Subject: Rezoning Petition Review

Rezoning Petition #: 22-048

Location of Property: Approximately 182.71 acres located along the south side of I-485 South interchange, east of John Adams Rd and north of N Tryon St.

RZ-2

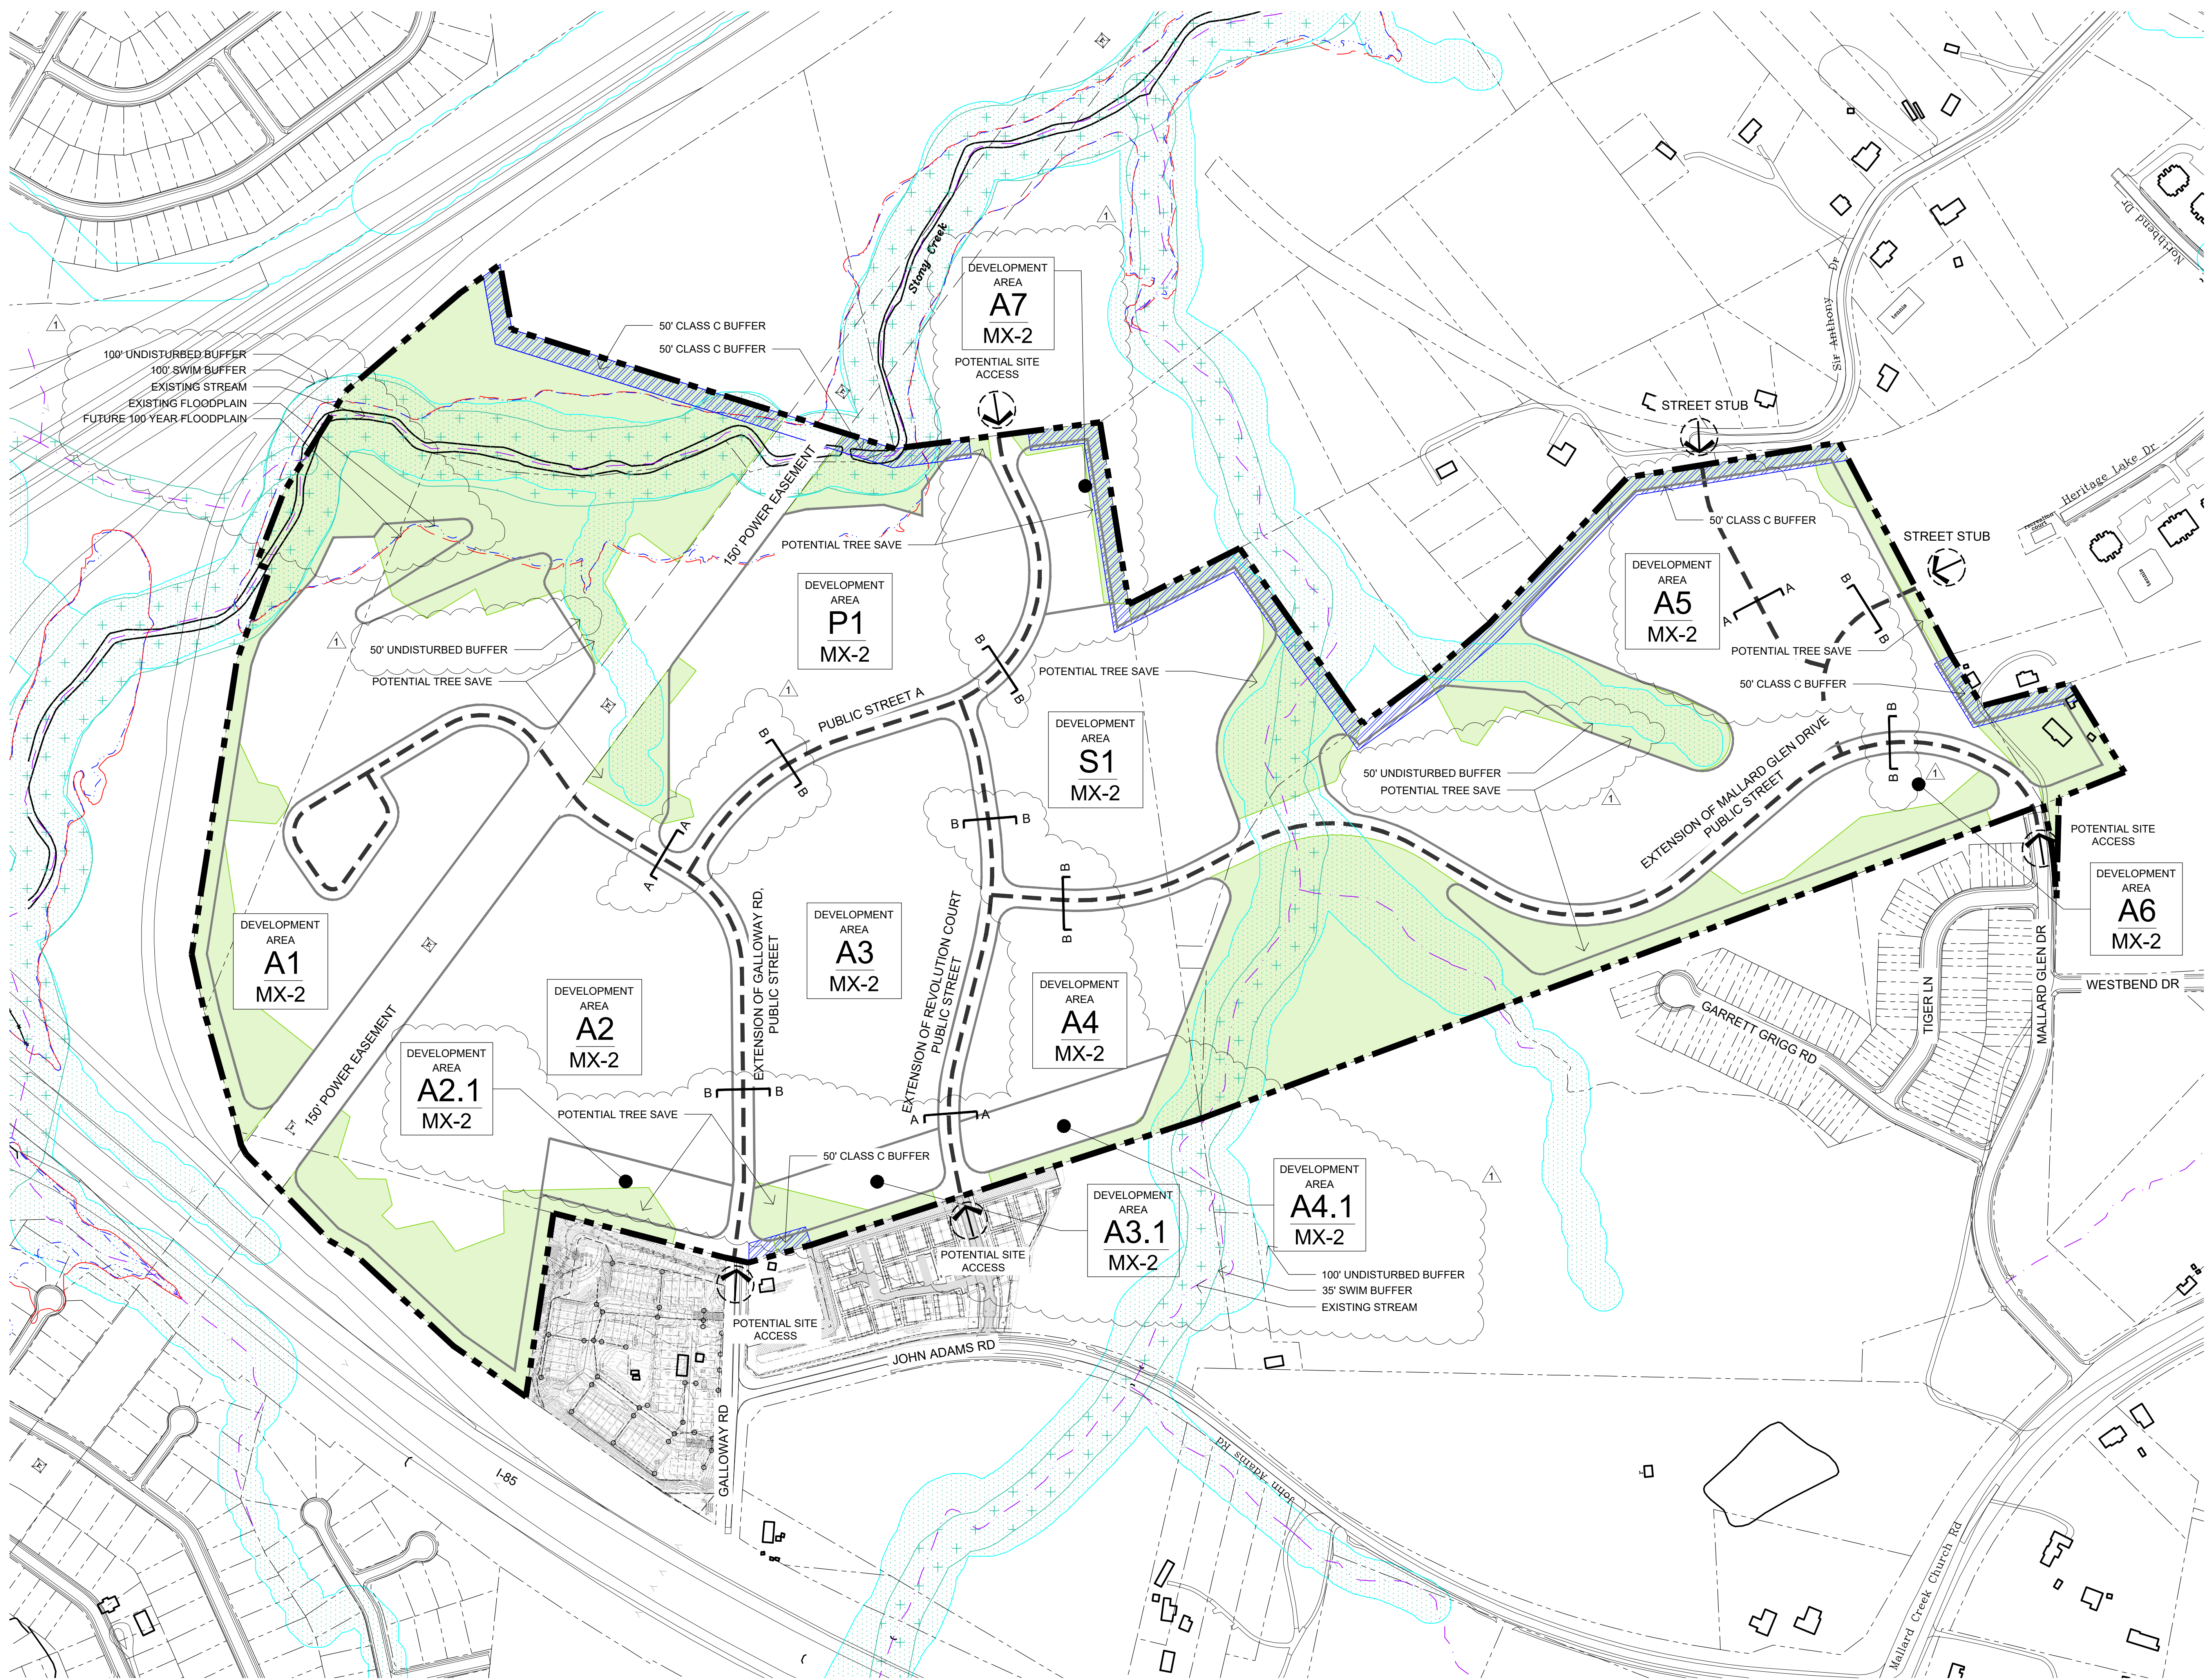
For the Yadkin Basin, petitioner is advised the 100' SWIM/PCSO Stream Buffers on the site may require the inclusion of 100% of the flood fringe area as additional stream buffer. Delineation of the additional stream buffer area may be deferred to the permitting process and is not required to be shown on the rezoning plan.

Please label stream buffers on the plan sheet and include the following note under *Environmental Features*: Development within any SWIM/PCSO Buffer shall be coordinated with and subject to approval by Charlotte-Mecklenburg Storm Water Services and mitigated if required by City ordinance. Petitioner acknowledges intermittent/perennial stream delineation reports are subject to review and approval upon submission of development plans for permitting and are not approved with rezoning decisions. The existing pond on site may require a buffer depending on results of the delineation report.
